# EL PASO COUNTY PLANNING AND COMMUNITY DEVELOPMENT DEPARTMENT

## GRADING AND EROSION CONTROL PLAN CHECKLIST

17066 SWMP\_Checklist

**ROCKY TOP RESOURCES**  
 GRADING & EROSION CONTROL PLAN INITIAL & INTERIM PHASES  
 TRACT 7 VALLEY GARDEN SUBDIVISION  
 1755 EAST LAS VEGAS STREET  
 COLORADO SPRINGS, COLORADO

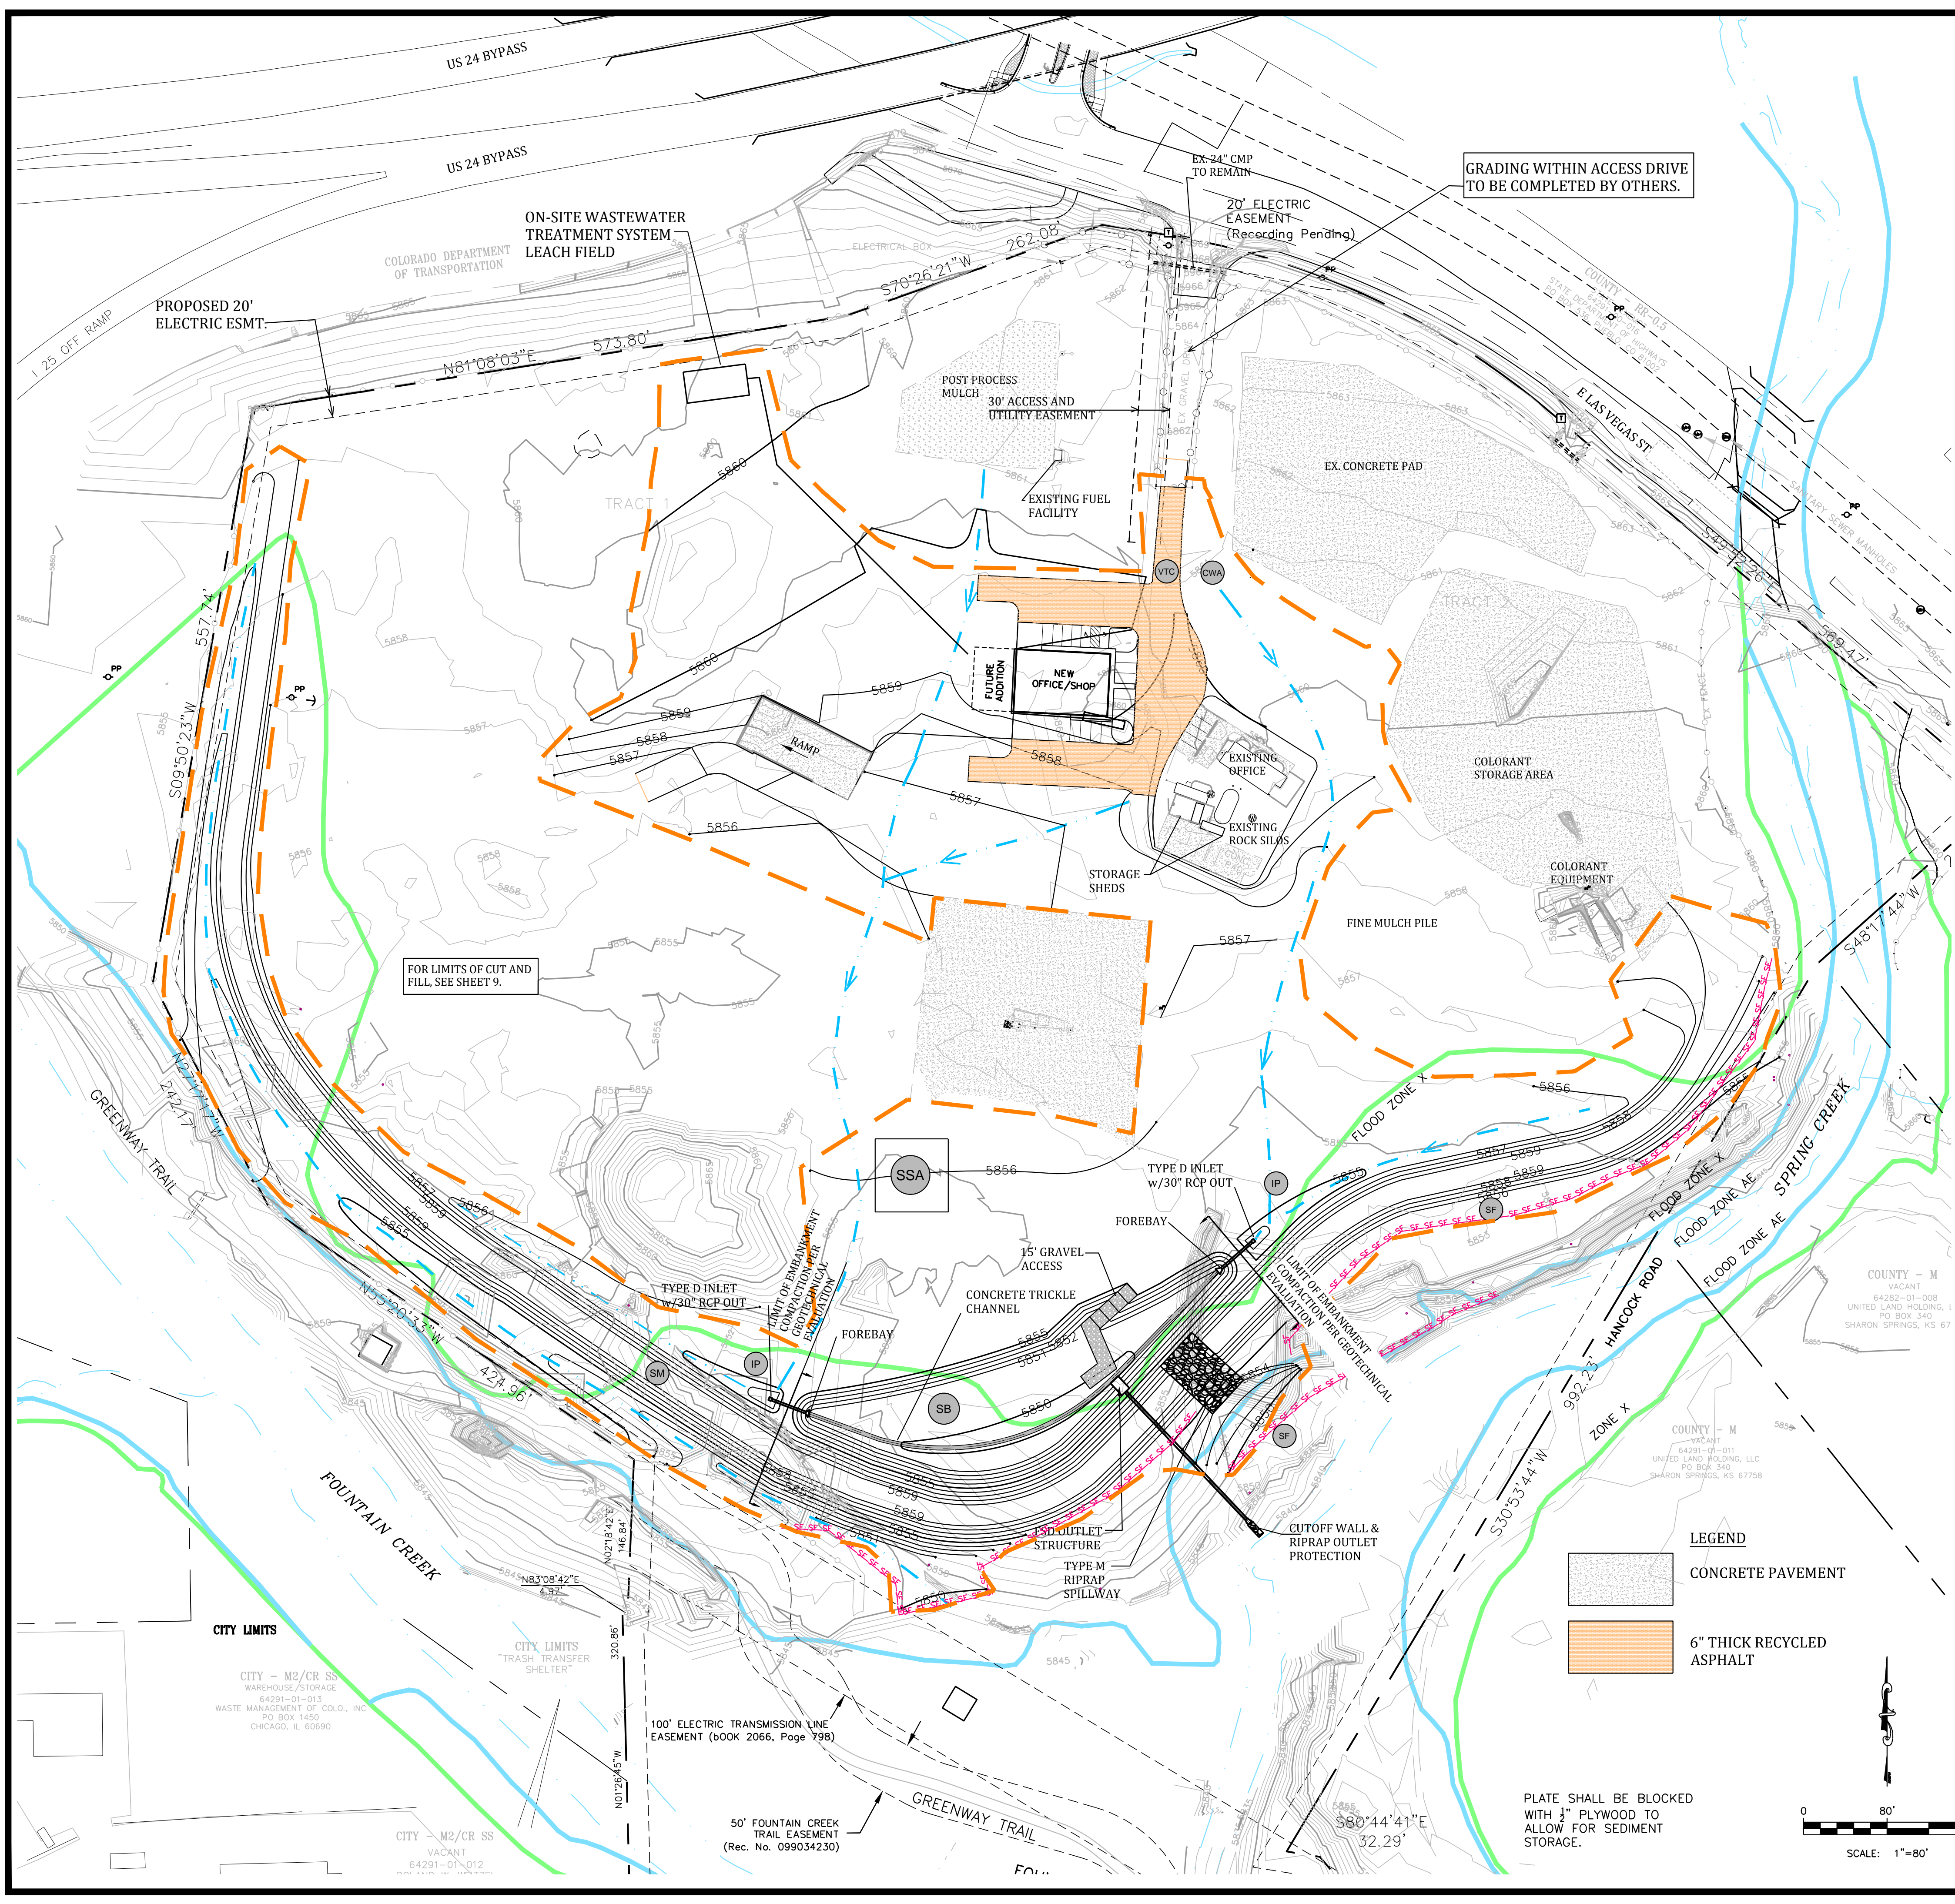
see  
 comment  
 on the  
 GEC  
 plan.

see comment on  
 GEC plan

Please revise this to  
 a "x" as a note was  
 provided on the plan.  
 Additionally, see  
 comment on the GEC  
 plan.

This must be addressed.  
 Please show all  
 existing/proposed easements  
 on the GEC Plan.

Please provide these  
notes on the GEC  
plan

N/A should not be indicated as all these notes must be included on the GEC plan

Please provide flow  
 arrows on GEC plan.
